DEVELOPMENT REVIEW BOARD  
TRANSPORTATION DEVELOPMENT

DRB Project Number: 2021-005597  
3901 Coors

SUBJECT: Plat, Infrastructure List

PLAT OF
LOTS 1 THRU 10
THE UNIVERSITY OF ALBUQUERQUE
URBAN CENTER
 WITHIN
THE TOWN OF ATRISCO GRANT
 IN
PROJECTED SECTION 2, TOWNSHIP 10 NORTH, RANGE 2 EAST
NEW MEXICO PRINCIPAL MERIDIAN
CITY OF ALBUQUERQUE
BERNALILLO COUNTY, NEW MEXICO
 NOVEMBER, 2021

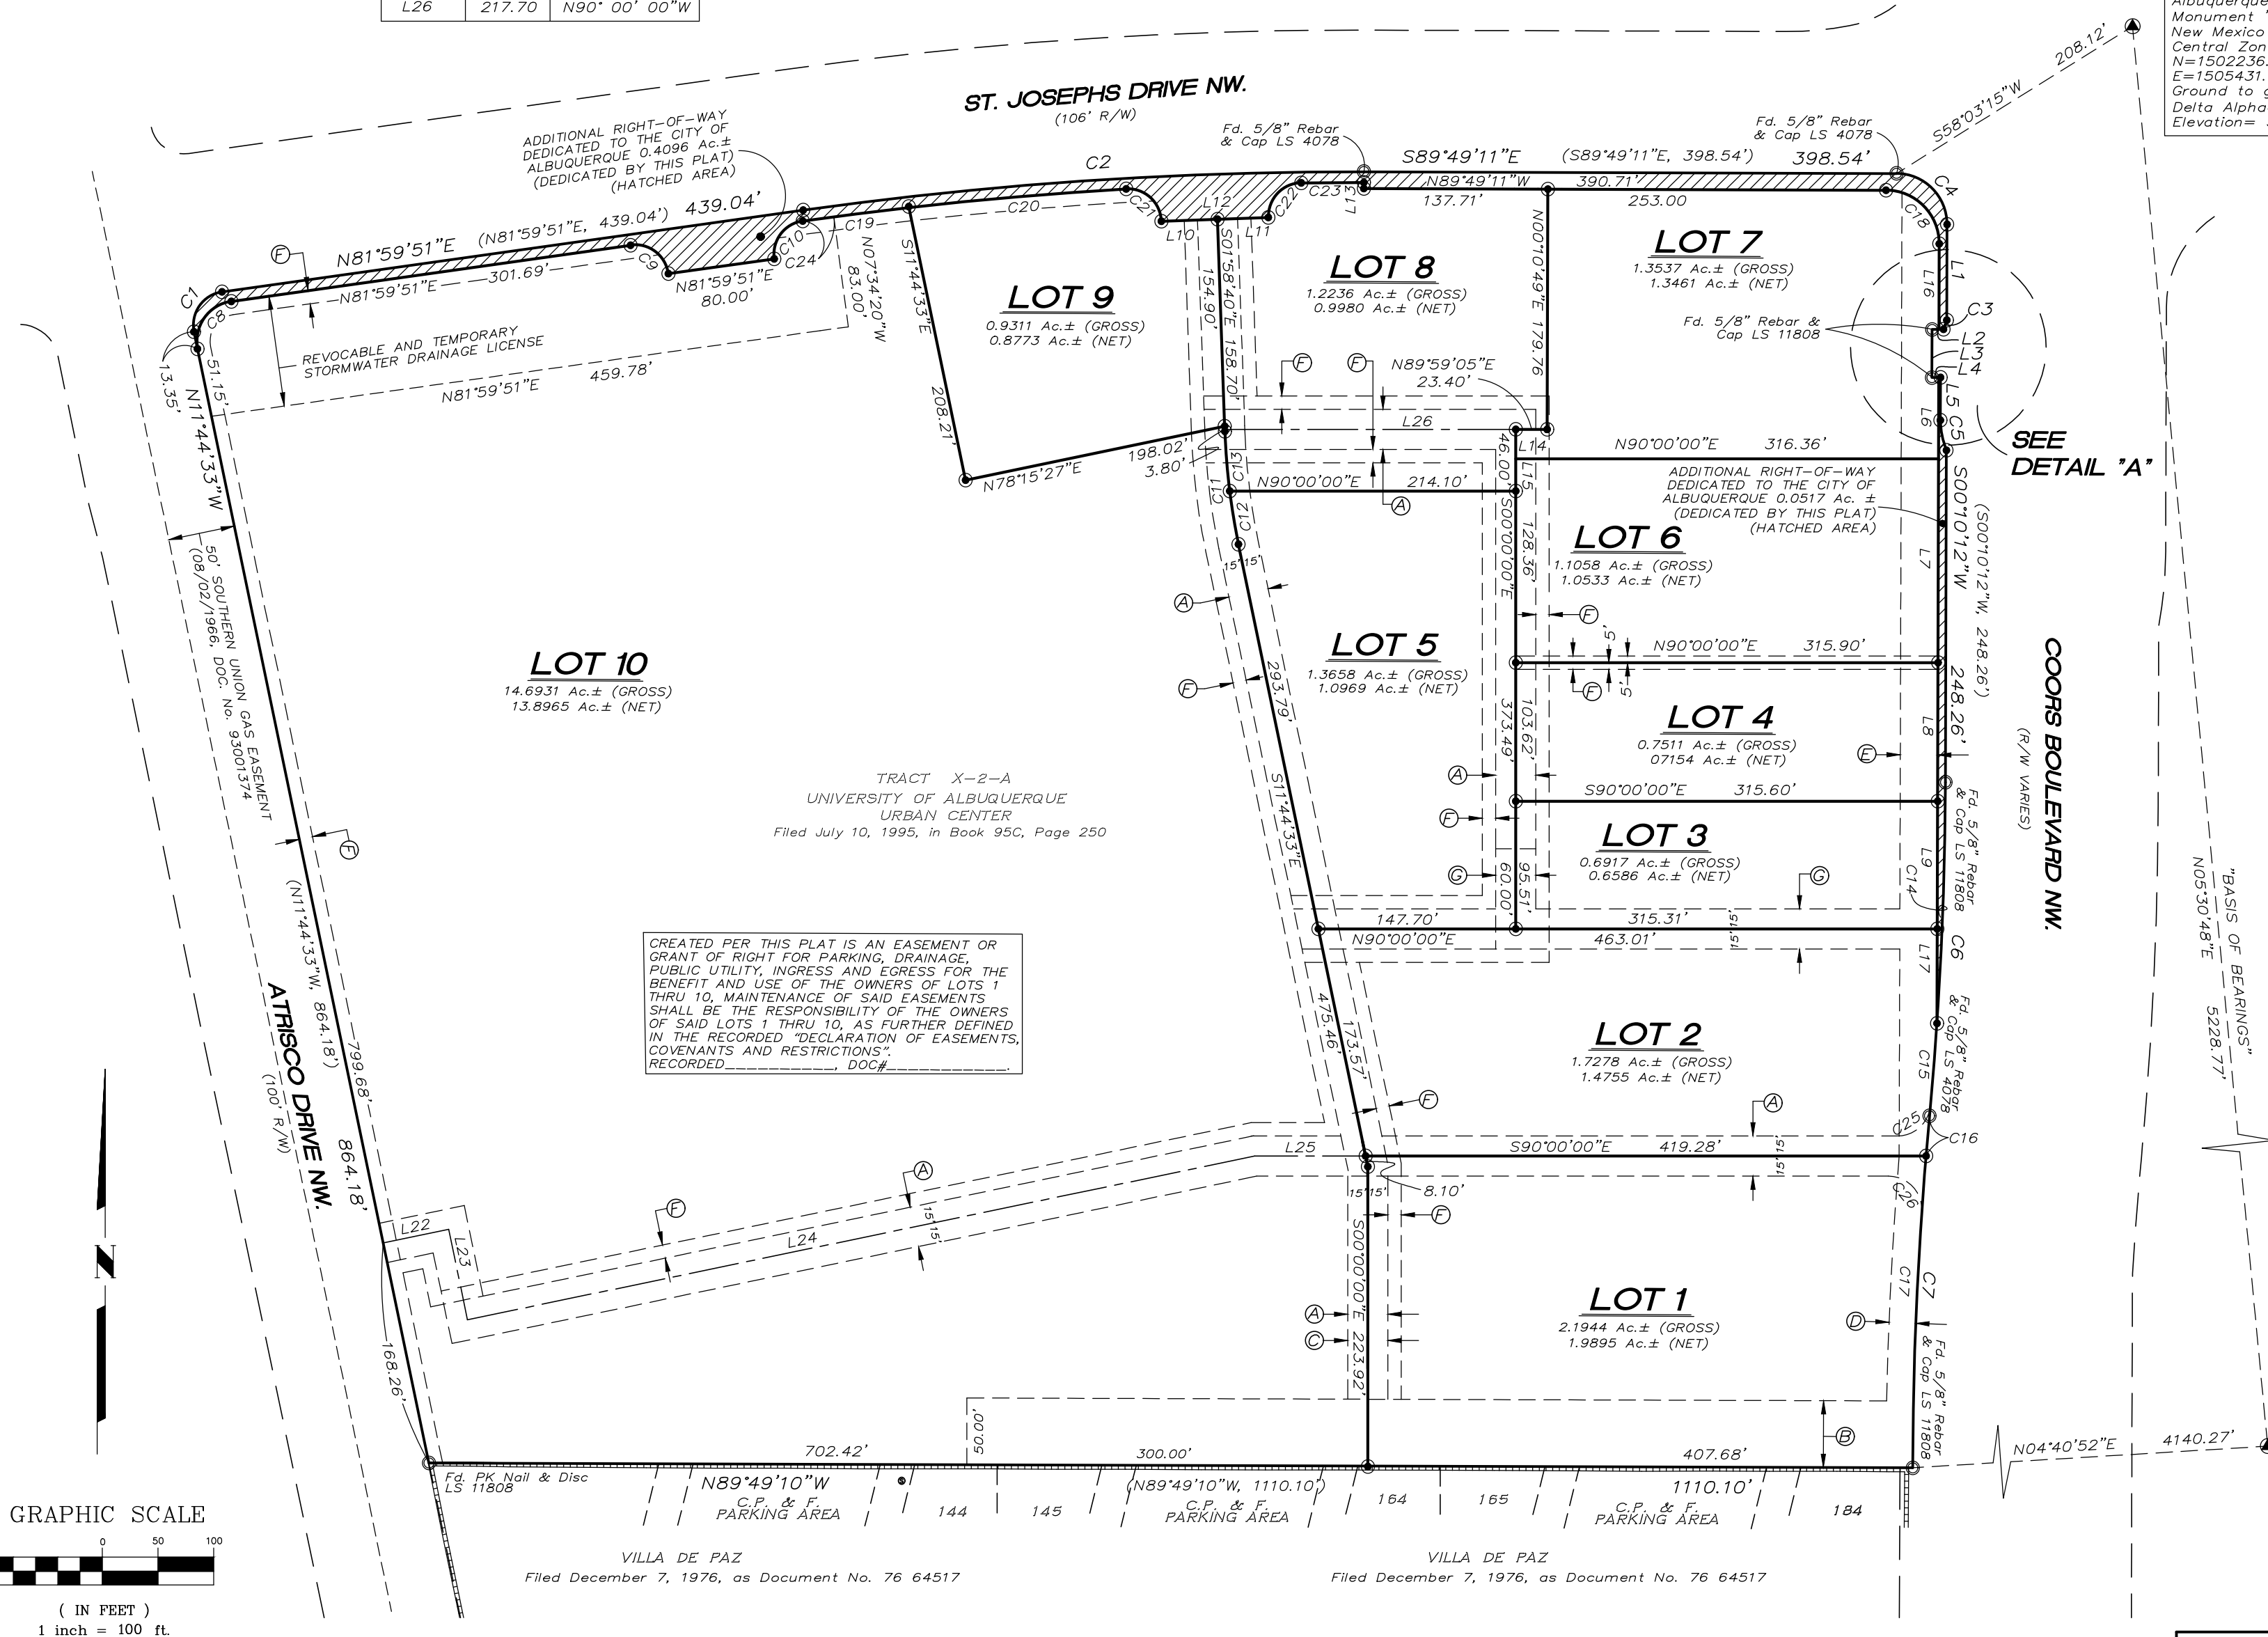
5. Provide the shared access on the infrastructure list (Reference "A" on the plat.) Define possible shared access between Lot 2 and 5 toward the west, or provide a turnaround if there is intended to be a dead-end access easement that is over 150 feet in length.

6. Lot 5 will require public sidewalk access to the right-of-way. Include this as part of a proposed access easement. Provide cross-sections for the various access easements, showing required road, curb, and any sidewalk.

7. For the shared access easement, provide curves along the boundaries of Lot 5 and Lot 10 for turning movements. These shall be designed to accommodate the specified design vehicle.

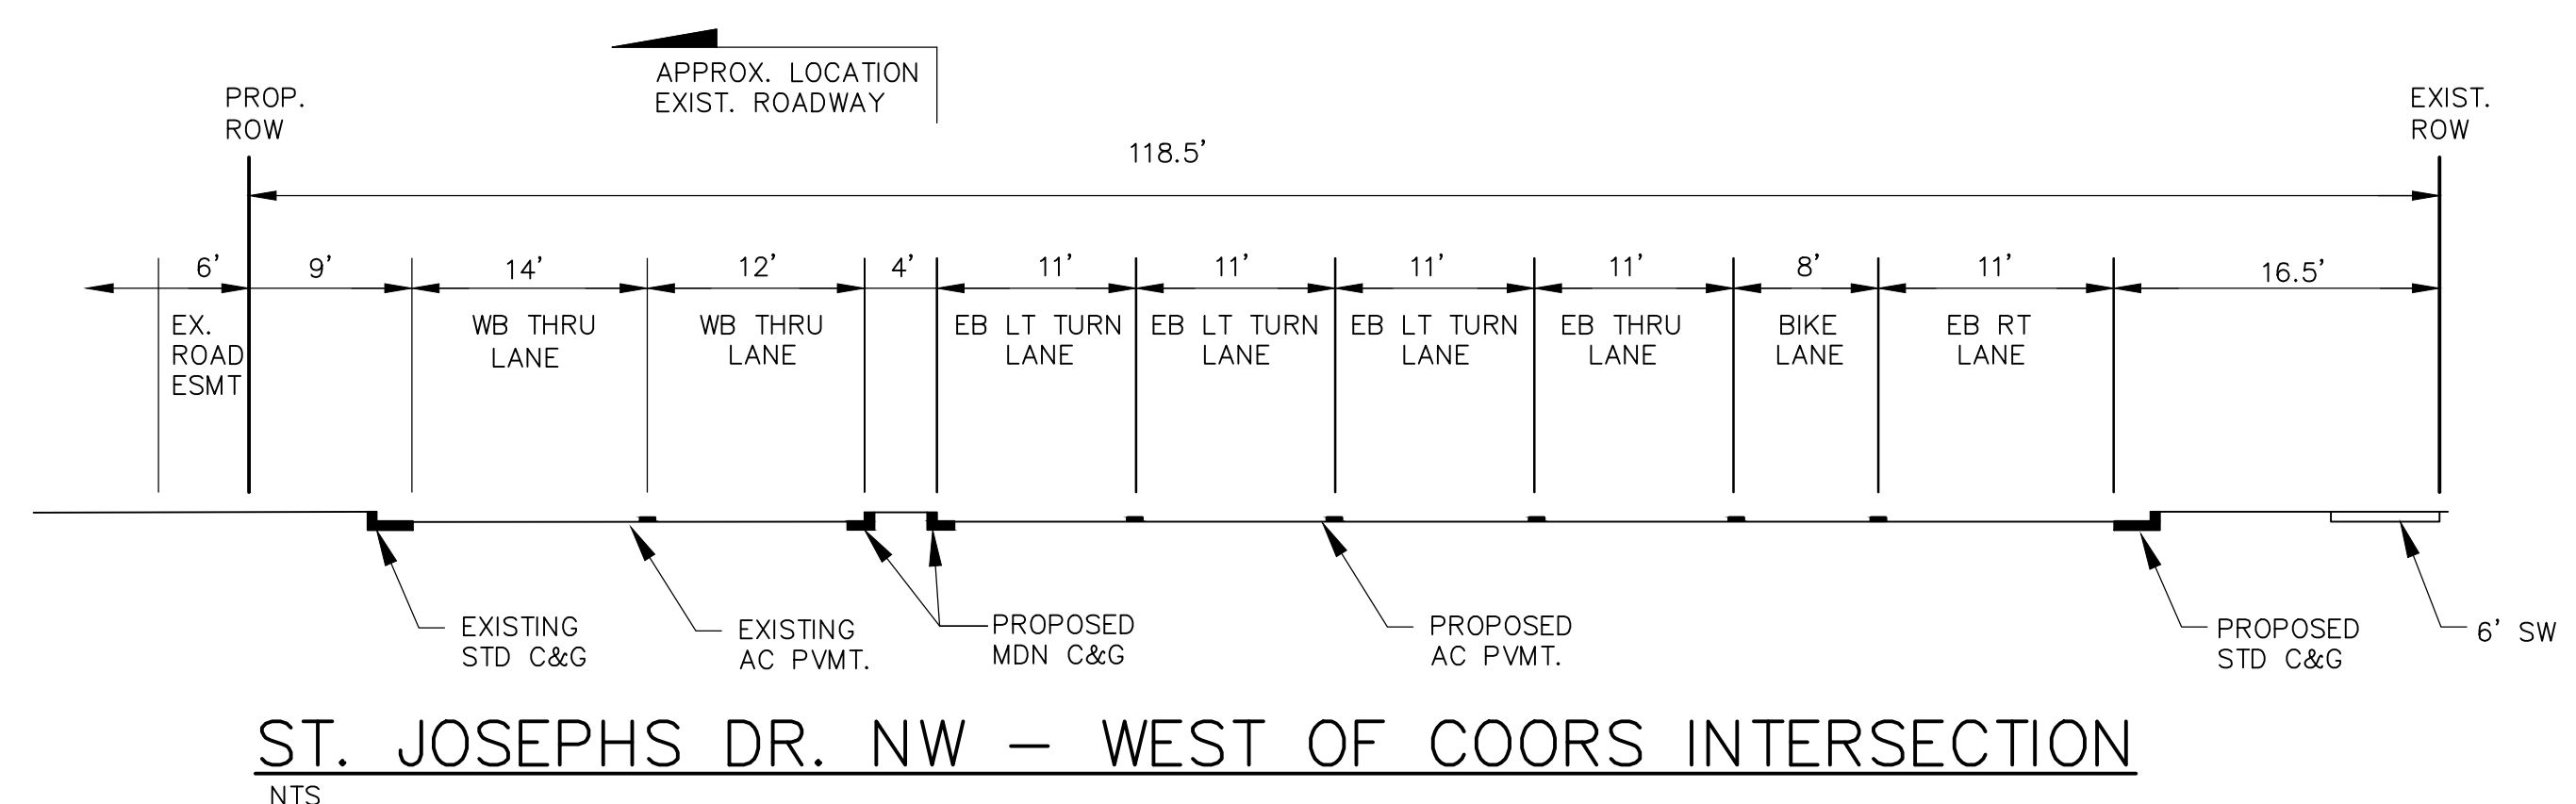
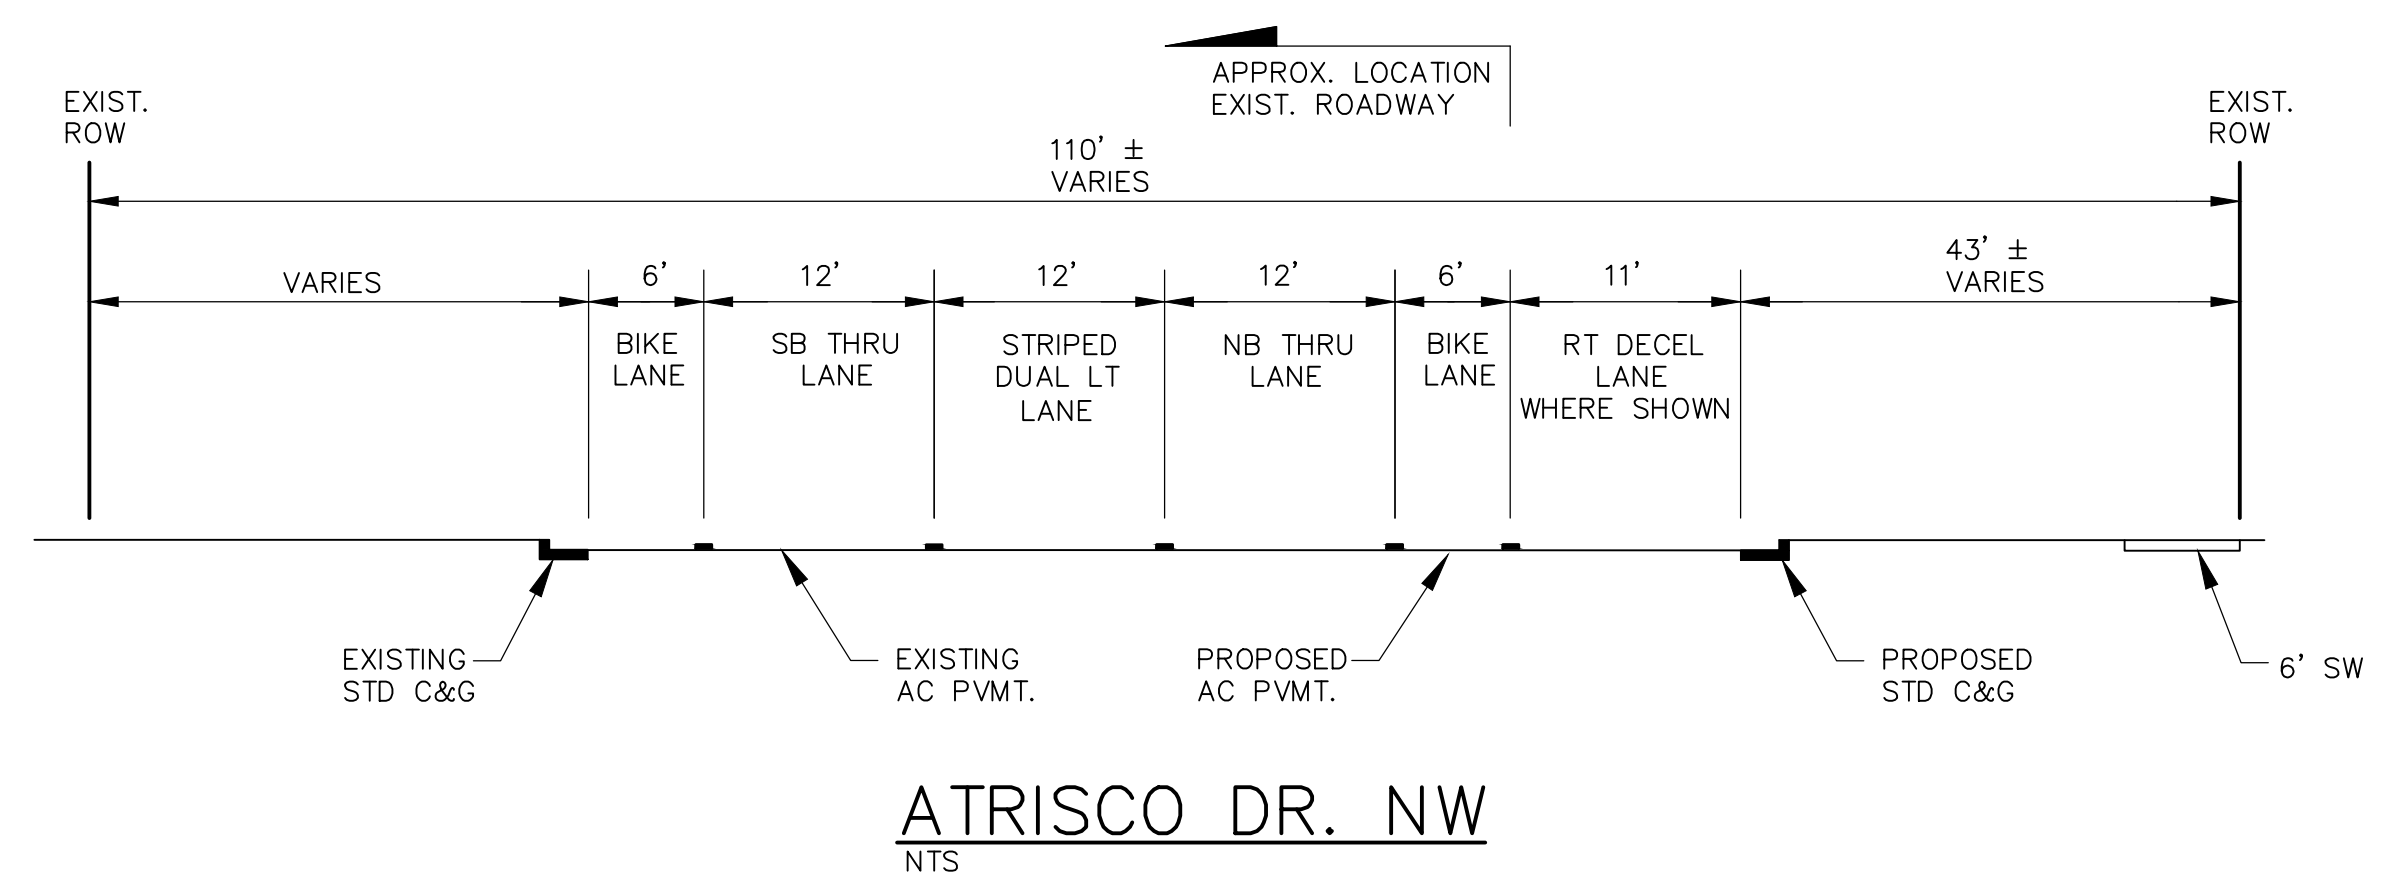
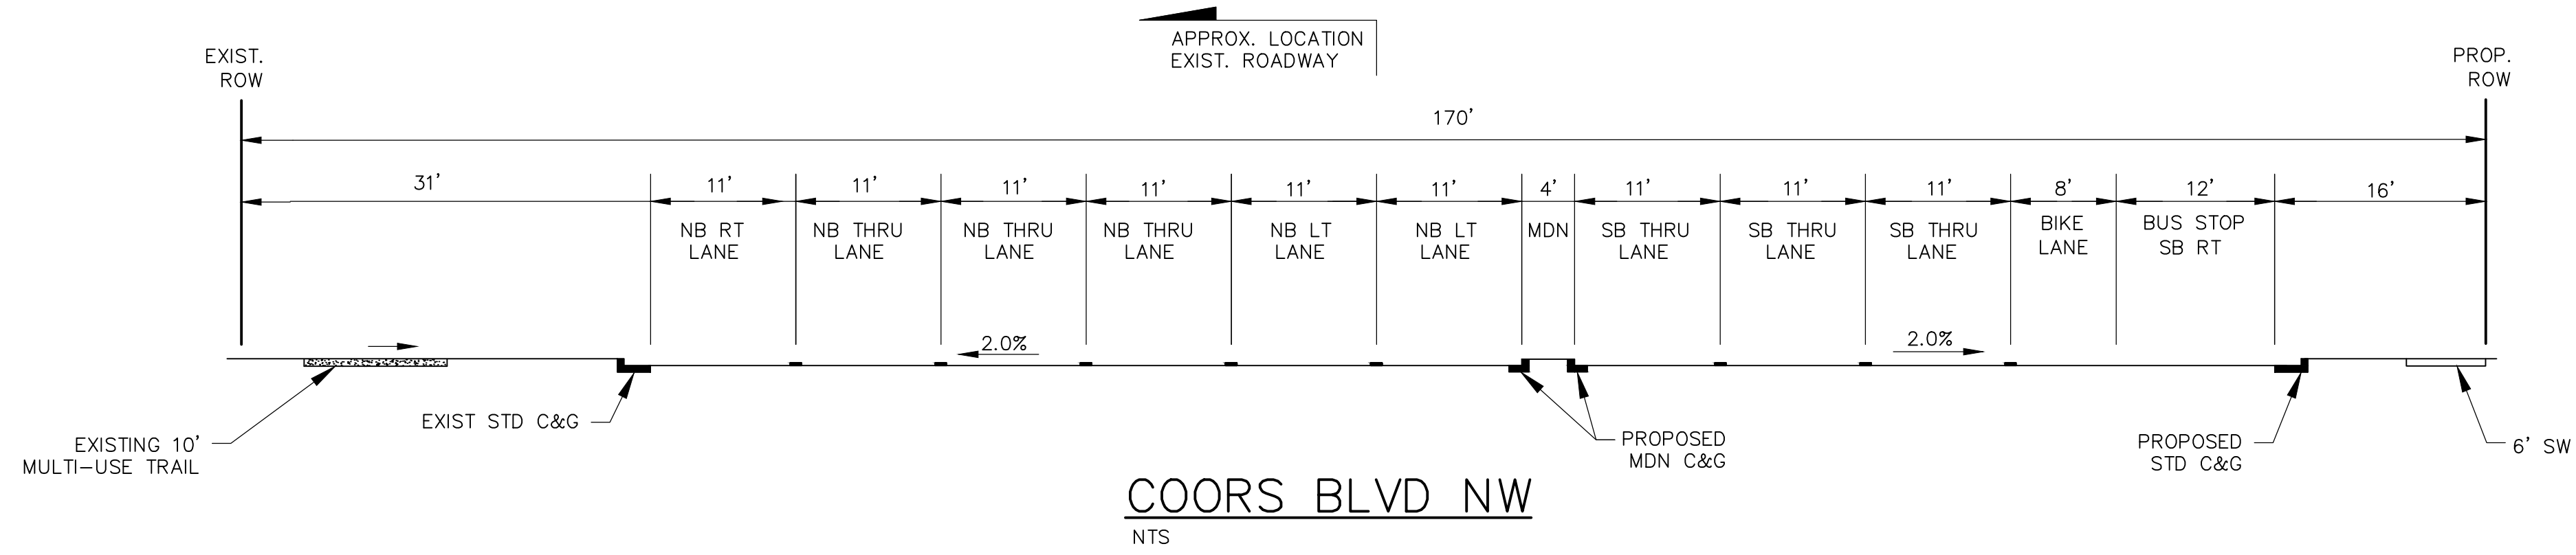
3. In a Center, 10-foot wide sidewalks are required along the arterial and collector streets per the new DPM requirements.
4. On the cross-section for St. Joseph's, reflect both existing and new right-of-way line along the south side of the roadway. Provide similar information for the other cross-sections.
